THE
ASTOR

25 October 2017

**Re: InterContinental Hotel and Transport House, Sydney – Concept Development
Application (Staged Development) for Alterations and Additions (SSD 7693)**

View Analysis

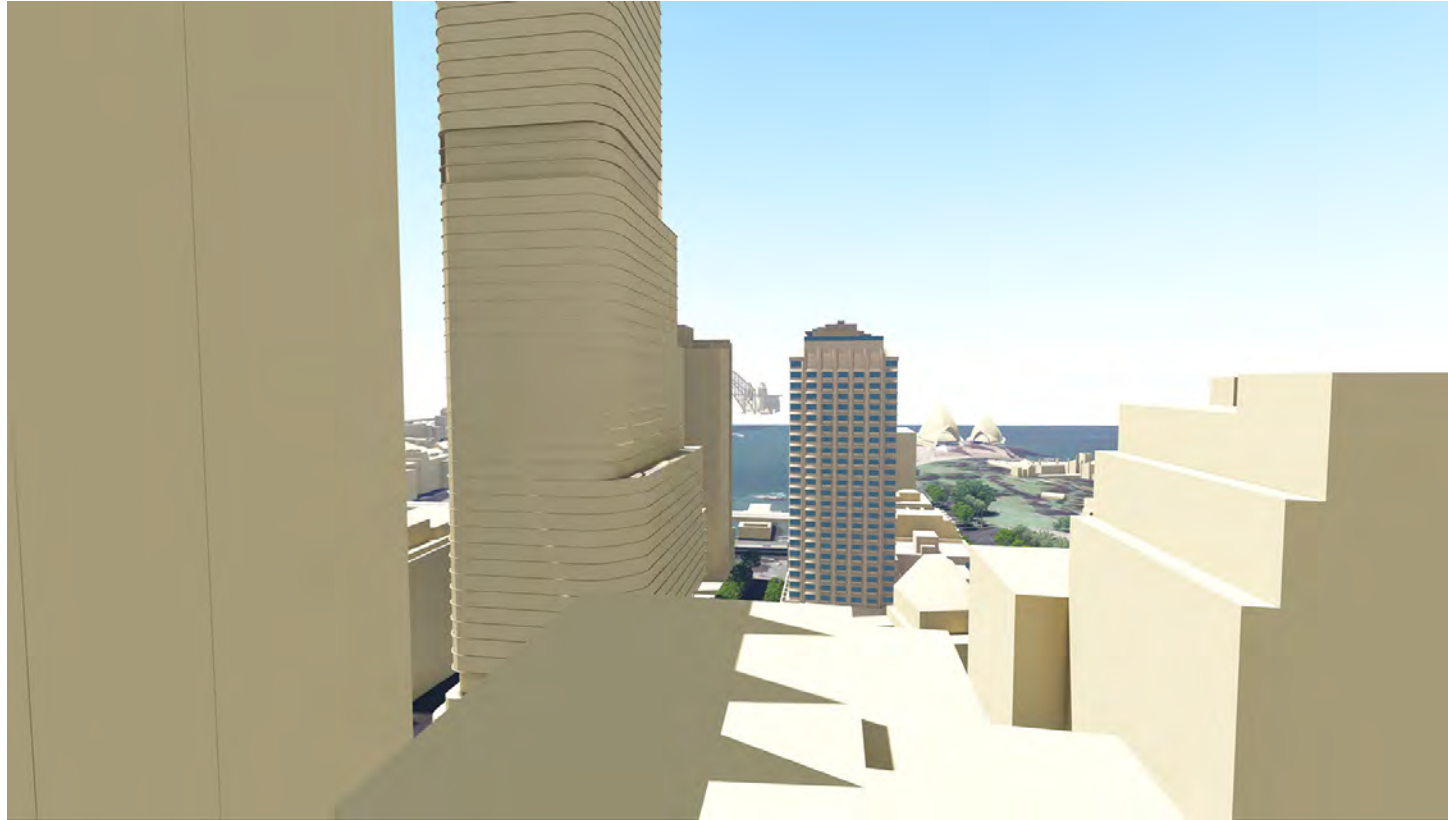
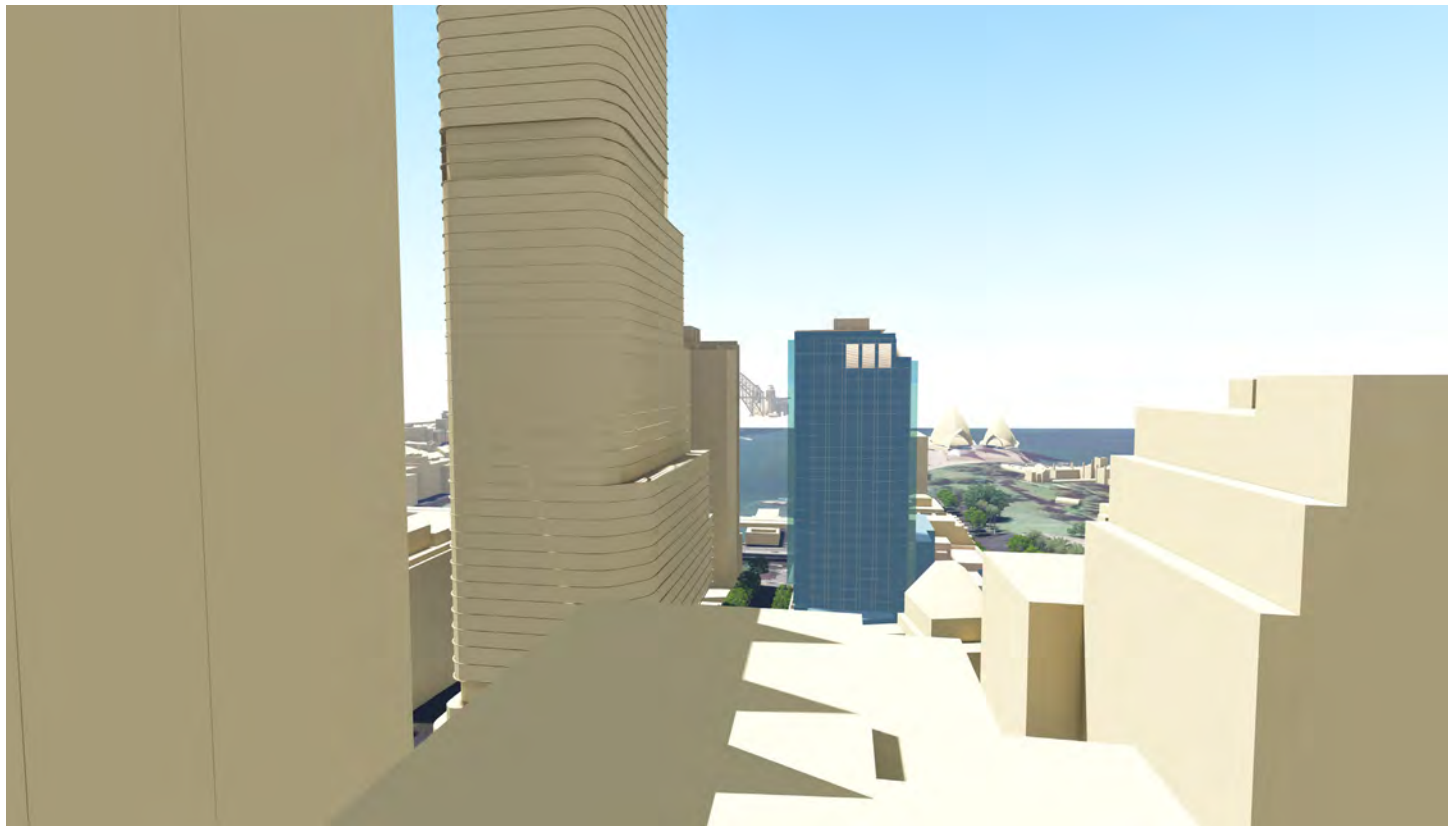
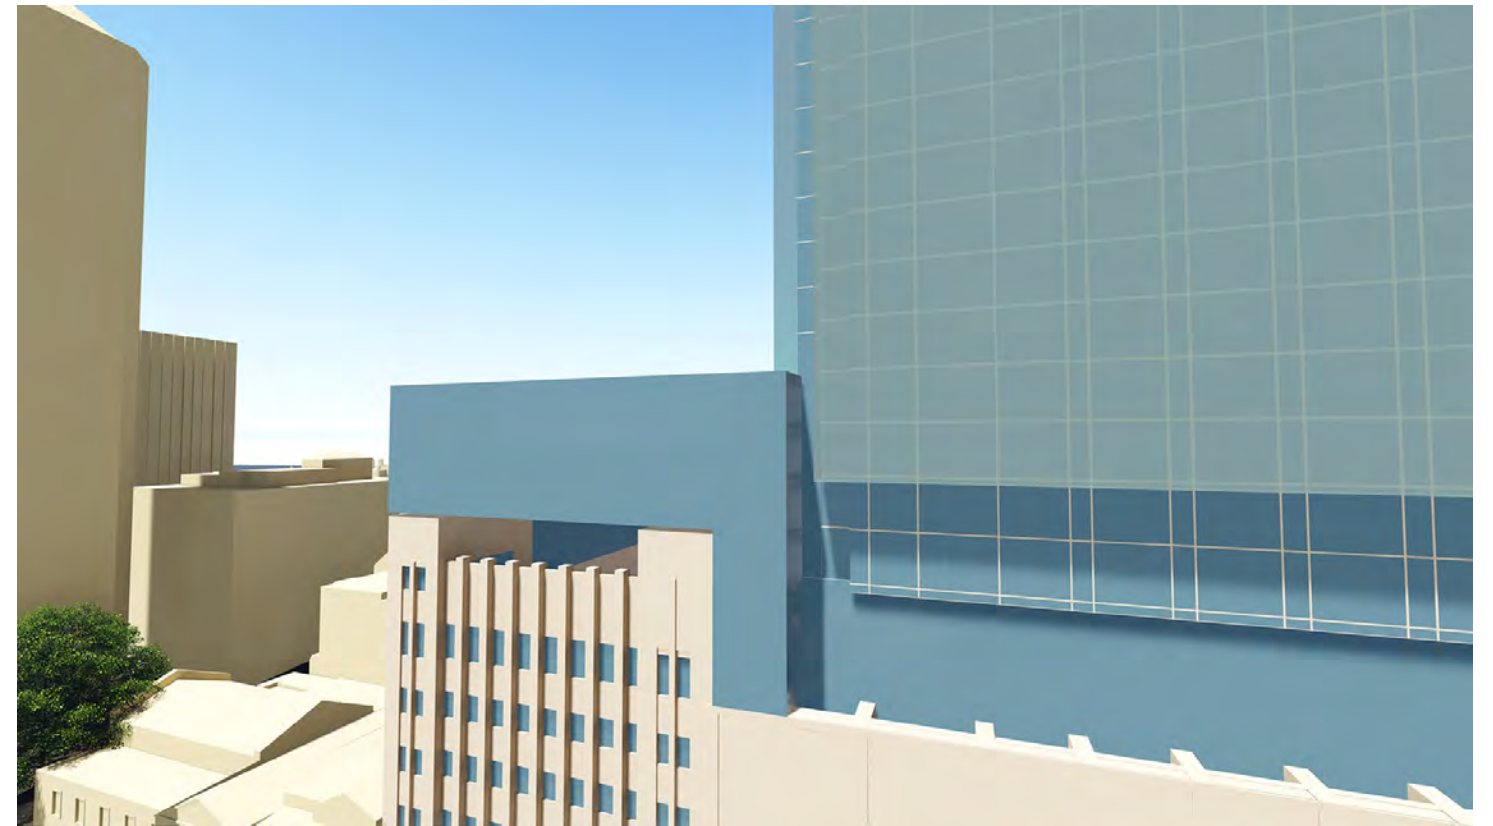
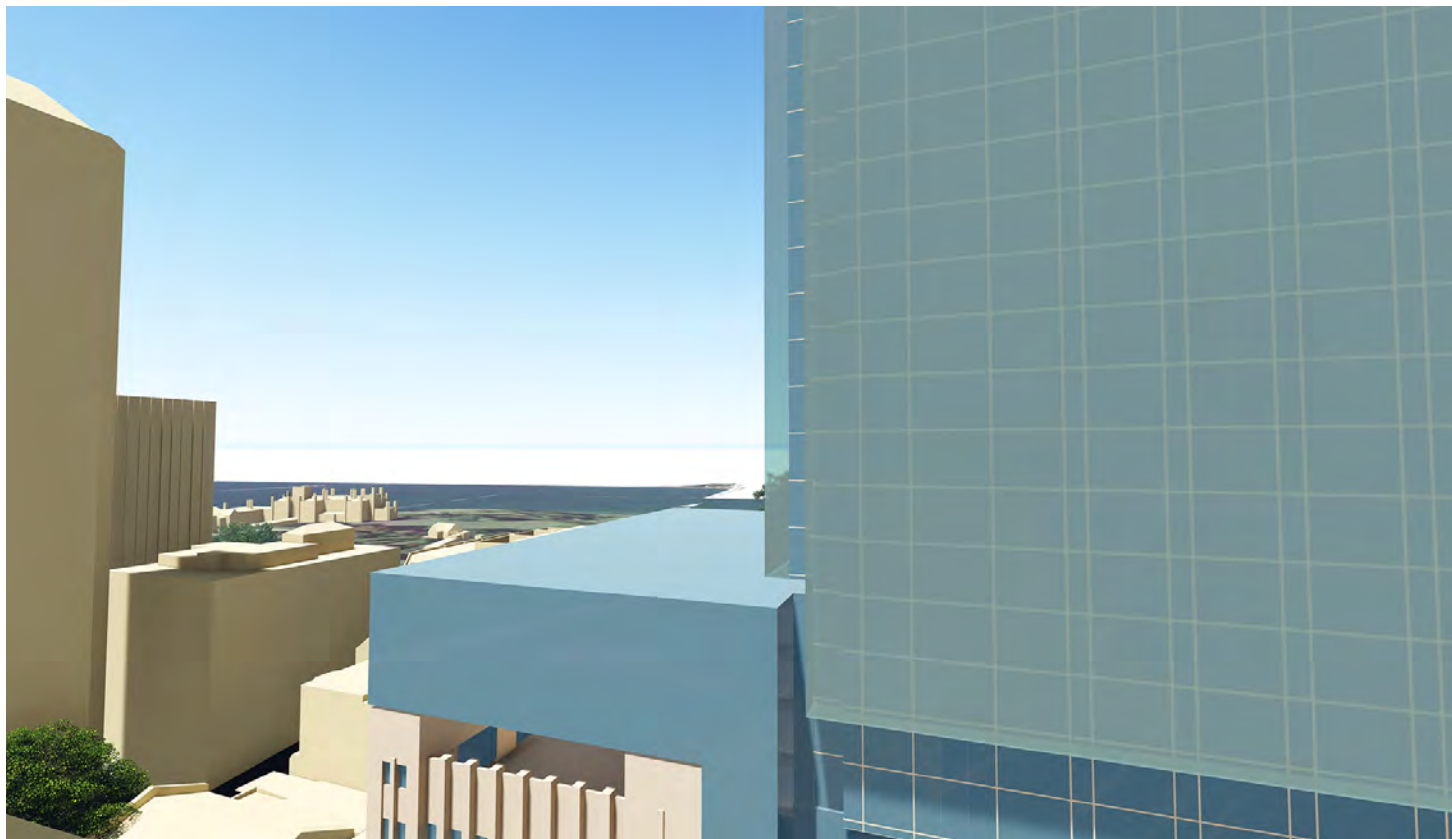
The view analysis fails to take into consideration the impact that the proposed works would have on views looking north up Macquarie Street.

In particular the views analysis does not consider the impact that the proposed building envelope will have on views from The Astor. The Astor is one of just a handful of old apartment buildings which survive on Macquarie Street. Since it was built in 1923 it has gradually become hemmed in by modern buildings.

Apartments in The Astor facing north, particularly from levels 8 upwards will be adversely affected, as will views from the rooftop of The Astor, which provides the only outdoor space to residents of the building (as the apartments do not have balconies).

SOUTH ELEVATION

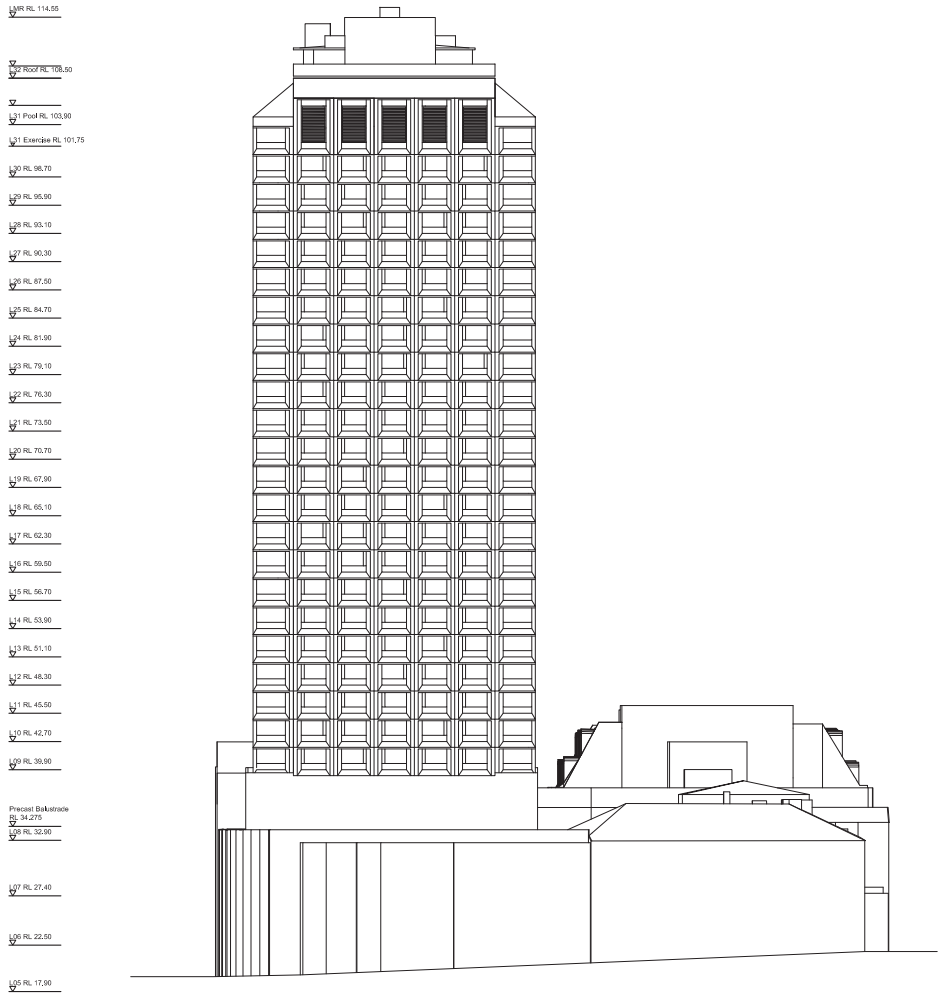
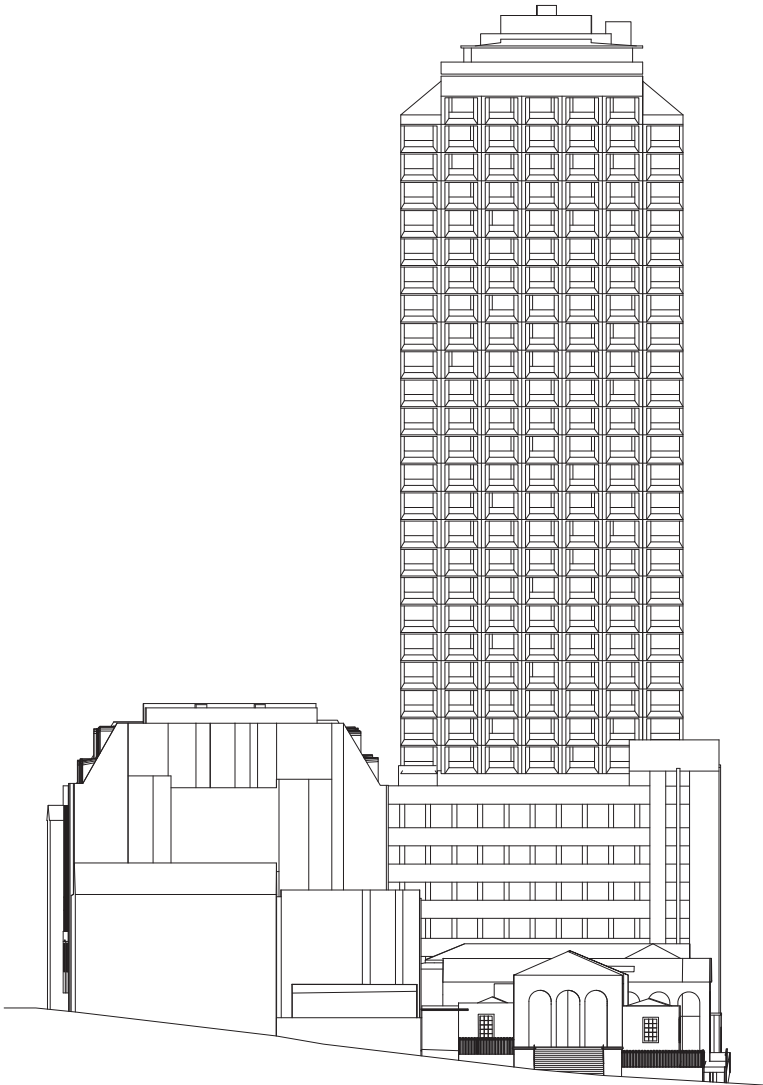
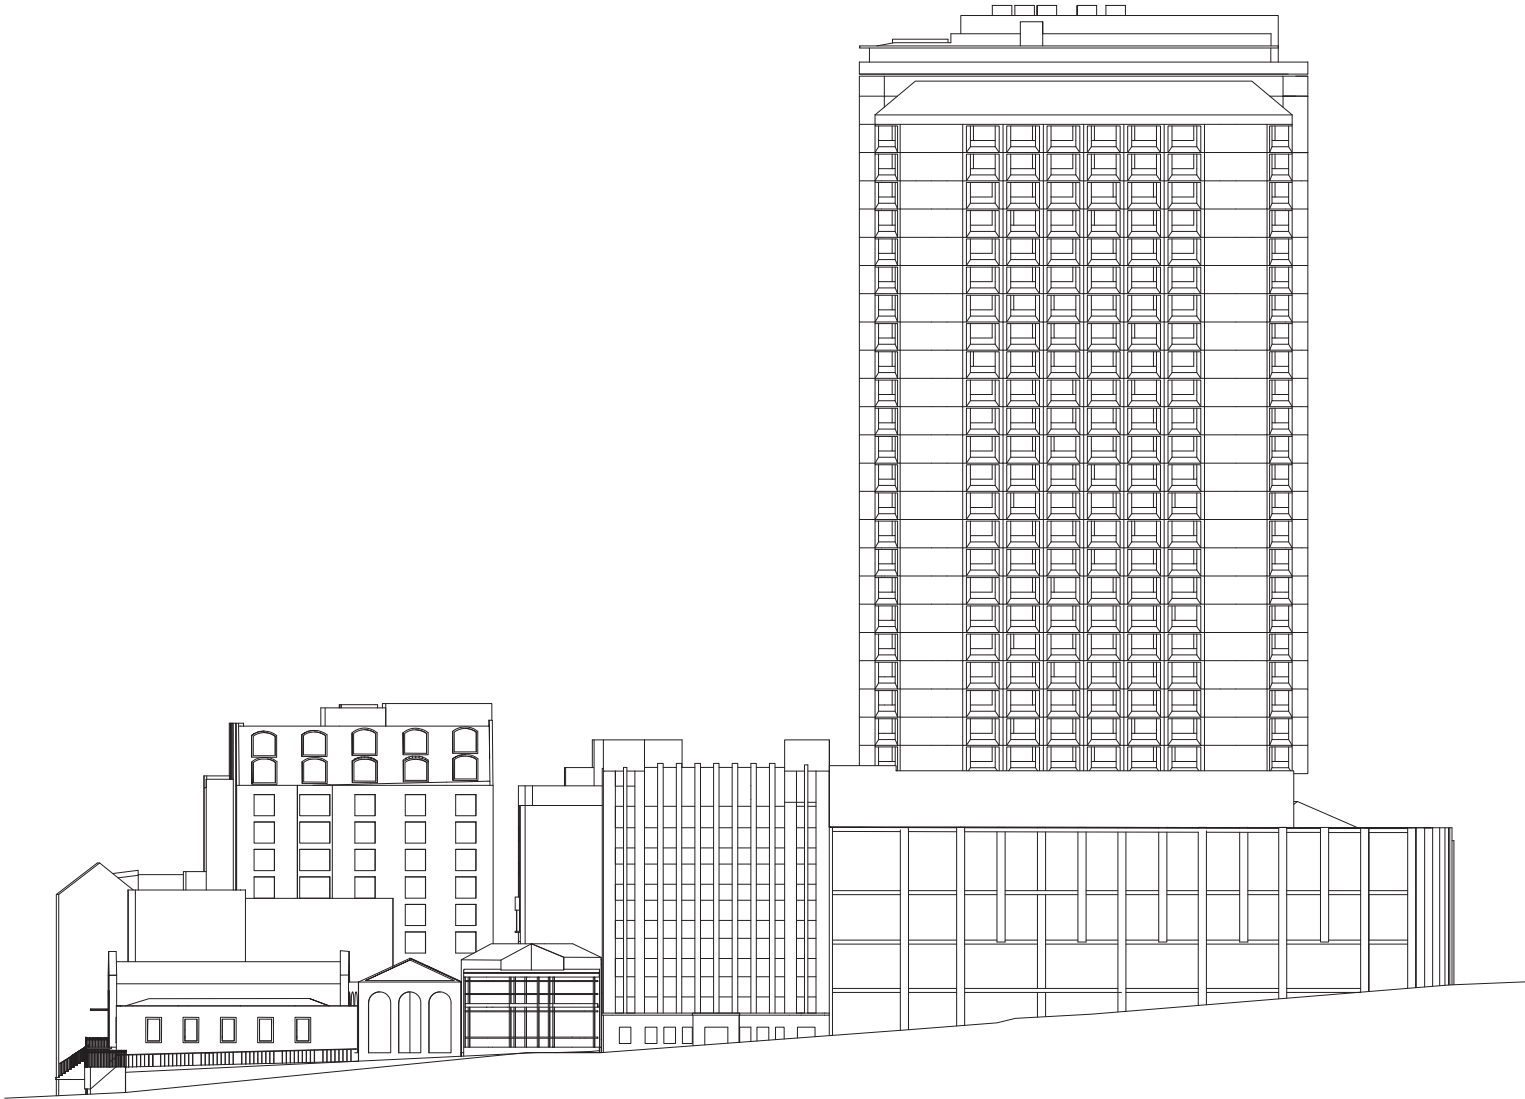
As evidenced in the Visual Impact Study, the re-location of cooling plant to level 8 of the South Elevation is visually prominent and detracts from the heritage façade of the Treasury building.
